Please find the following summary of changes that have been updated on our drawings for the Residential Building R5 RTS SSD6966 following your email on the 29 April 2019. These drawings are numbered as follows

- RPB430-GE-R5000-GA Revision R – General Arrangement
- RPB430-GE-R5001-GRND Revision O – Ground Floor
- RPB430-GE-R5002-PO2 Revision N - Podium Level 02
- RPB430-GE-R5003-L26 Revision N – Level 26
- RPB430-SE-R5004 Revision H – Podium Level 02
- RPB430-SE-R5005 Revision A – Section Public Domain
- RPB430-SE-R5006 Revision A – Waterman's Quay
- RPB430-SE-R5007 Revision A – Hickson Road

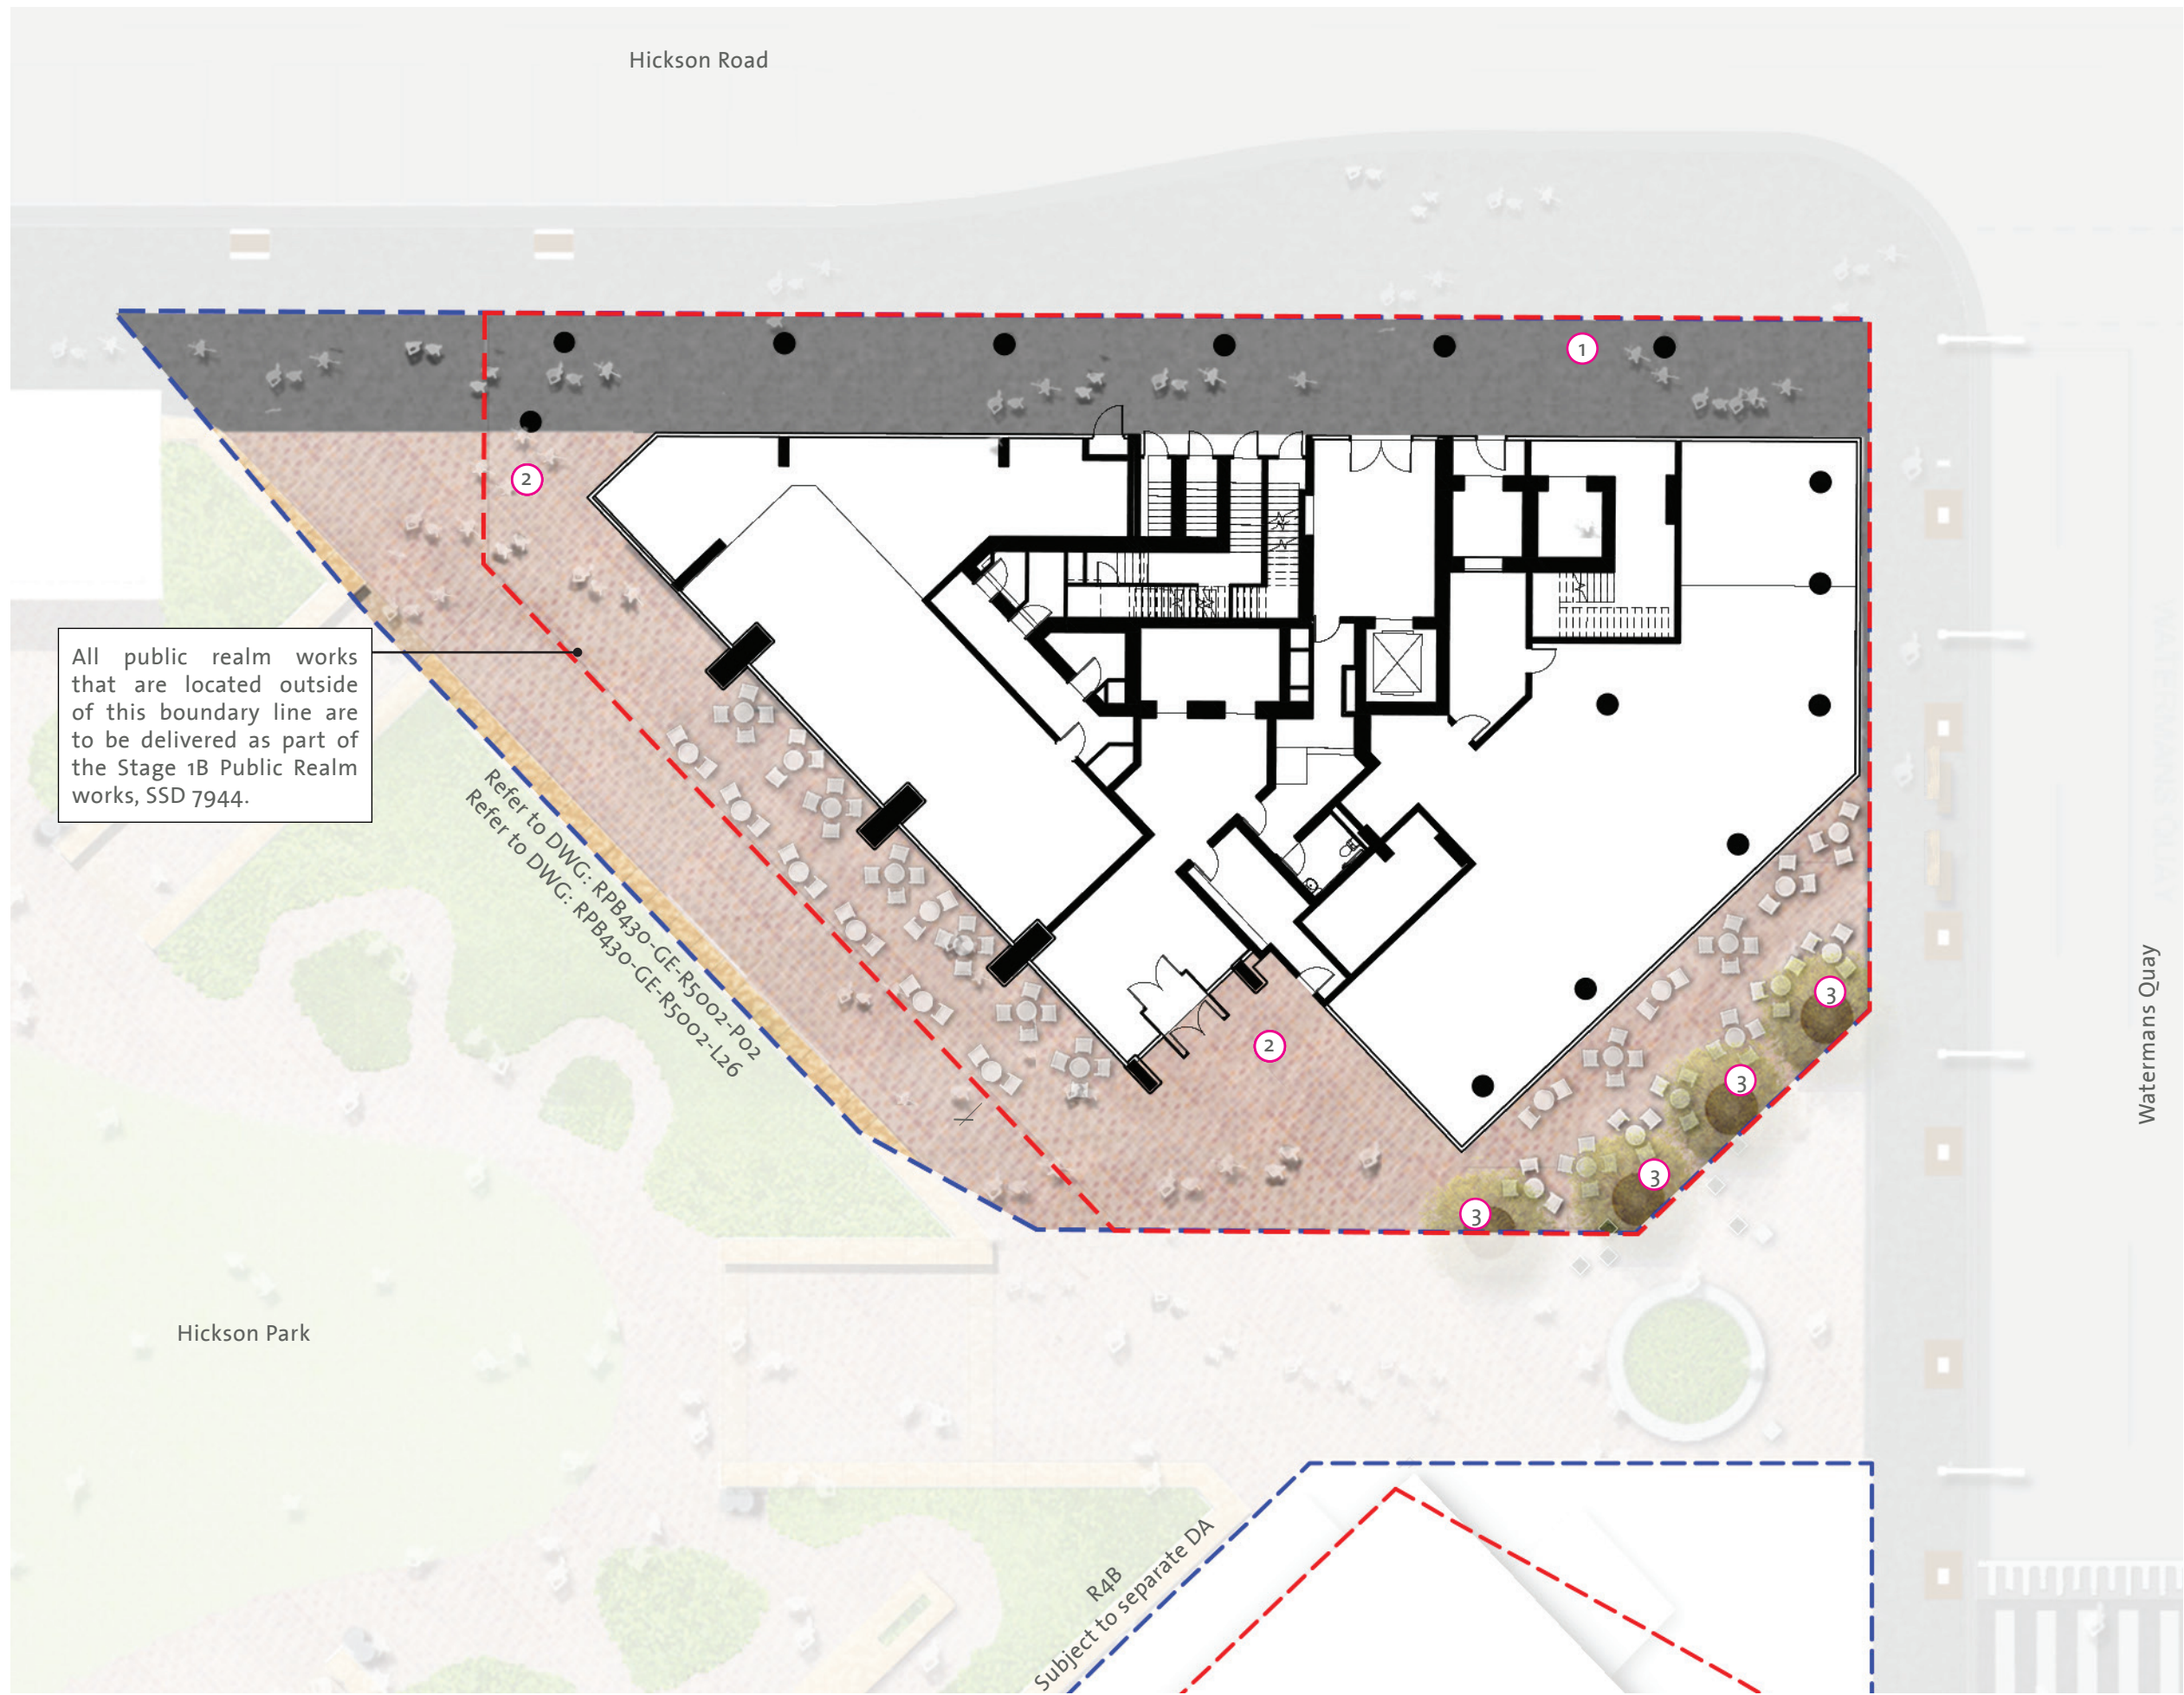
Provide details of the trees proposed at ground level within the plaza

Amend the Landscape Plans to provide design criteria to confirm the recommendations of the wind impact assessment have been incorporated into the design of the ground level and podium. Consideration should also be given to the interaction of the development with Hickson Park.

The tree pits will be provided with adequate volume (typically 16-18m³ per tree) and depth (minimum of 1000mm) for growing media. They will include appropriate drainage, aeration and irrigation. The proposed tree species, height and diameter are shown on drawing RPB430-GE-R5001 GRND Revision 0 – Ground Floor.

Please refer to revised drawing RPB430-GE-R5001-GRND Revision O – Ground Floor

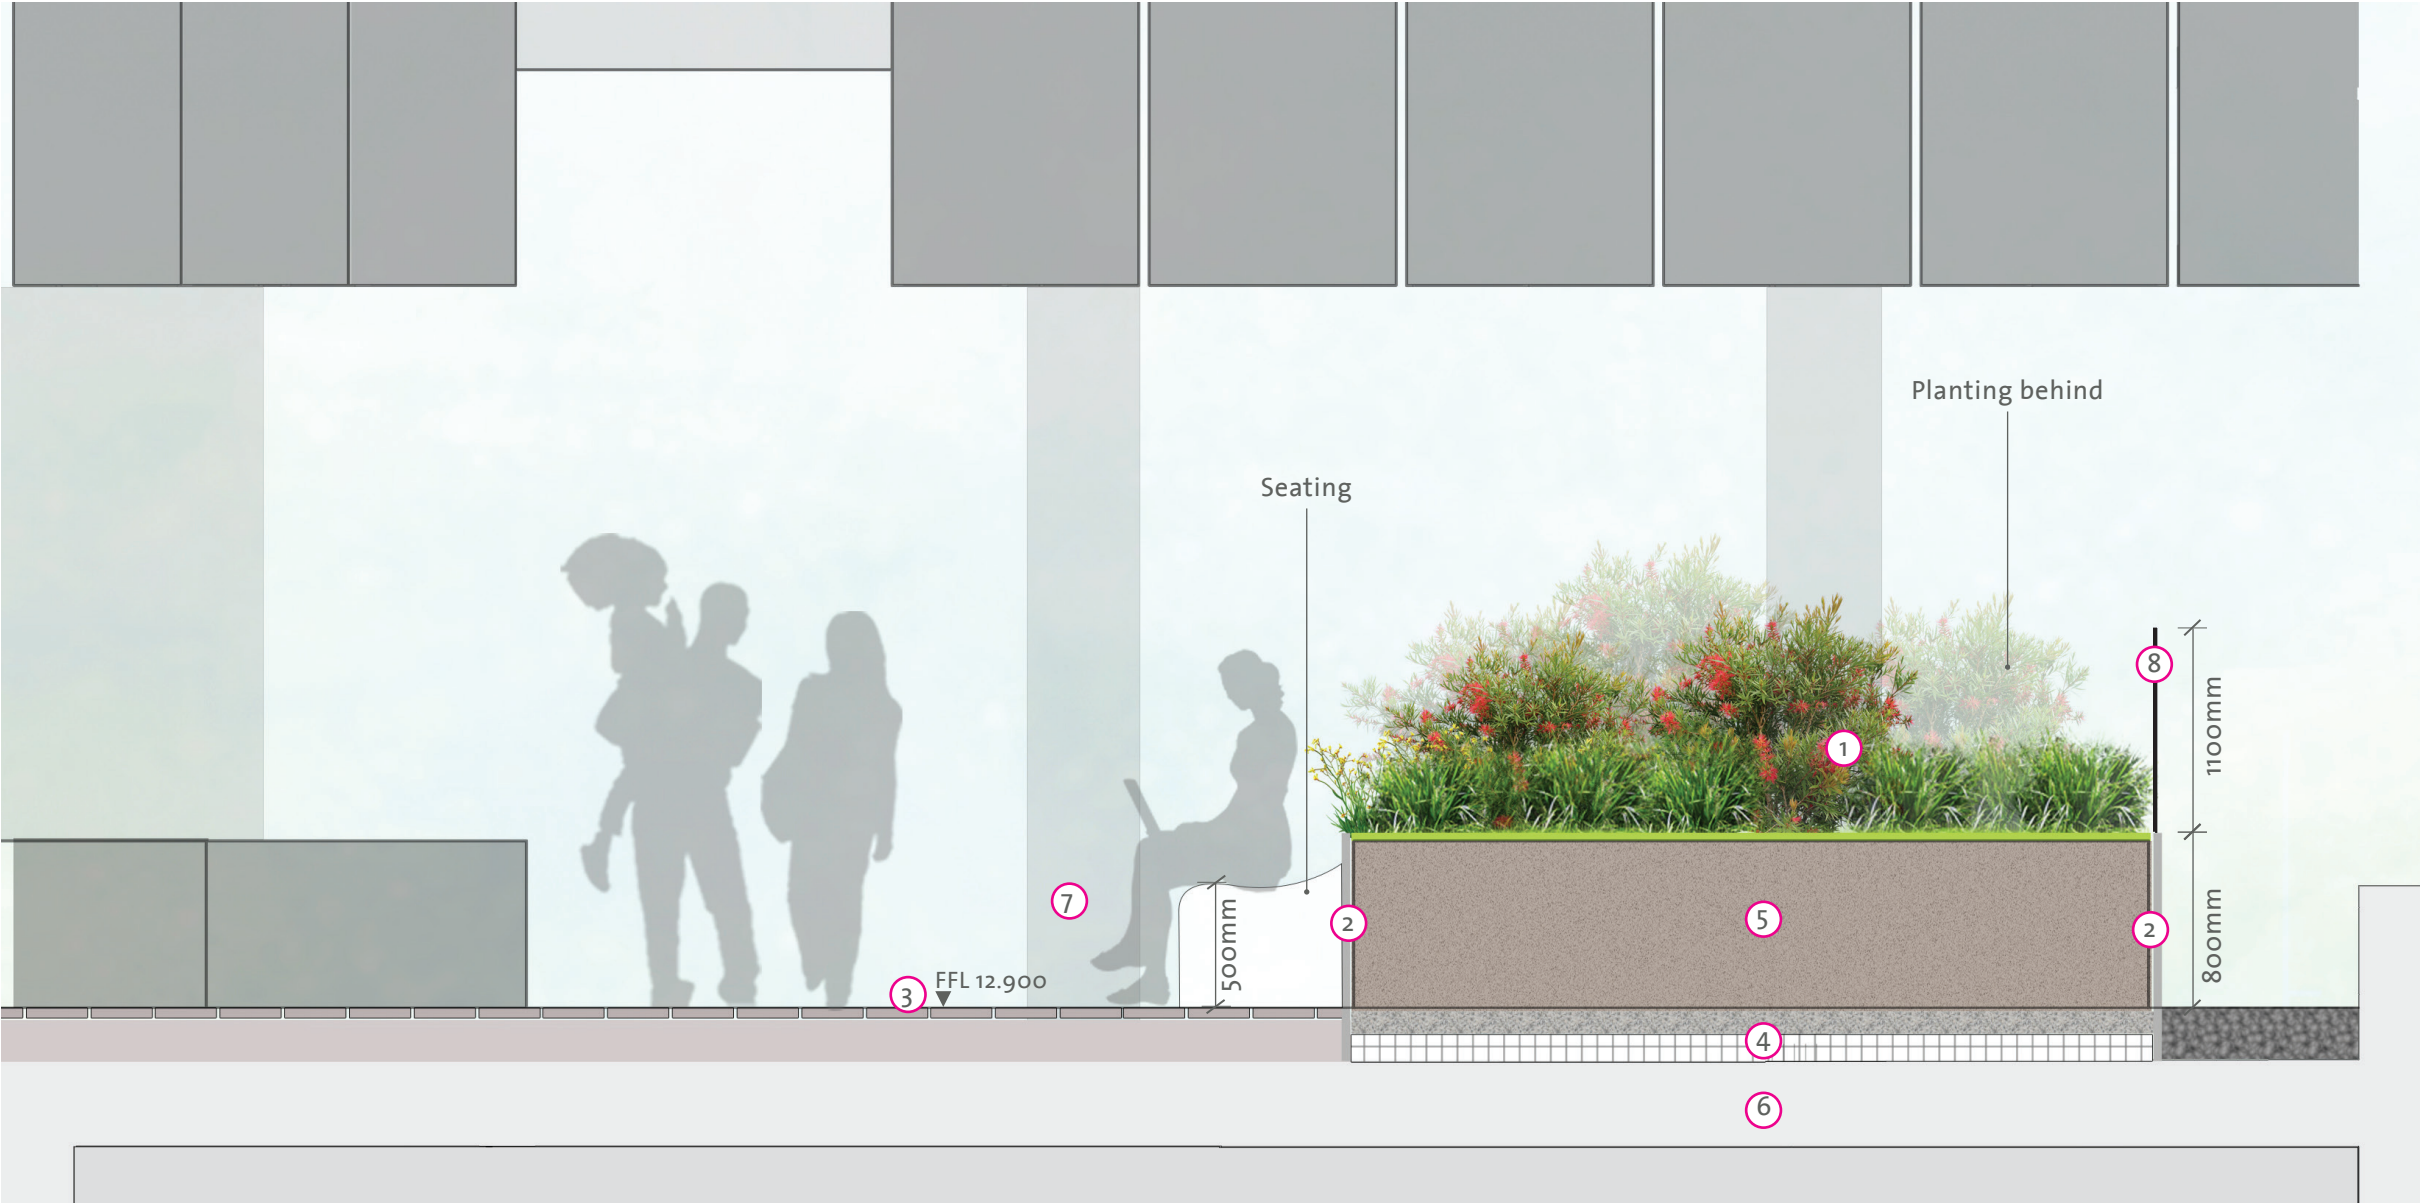
Provide further details and justification regarding the interface of the development with the surrounding public domain, including Hickson Park, Hickson Road and Watermans Quay. This shall include section drawings, discussion of changes in levels and any implications for accessibility.

We have included new sections to show the interface with the public realm, Hickson Road and Watermans Quay. Refer the drawings in the list above. The landscape seamlessly integrates with the levels of the adjacent street and pathways, without steps, and complies to the requirements of acceptable crossfalls defined in the current Australian Standards.
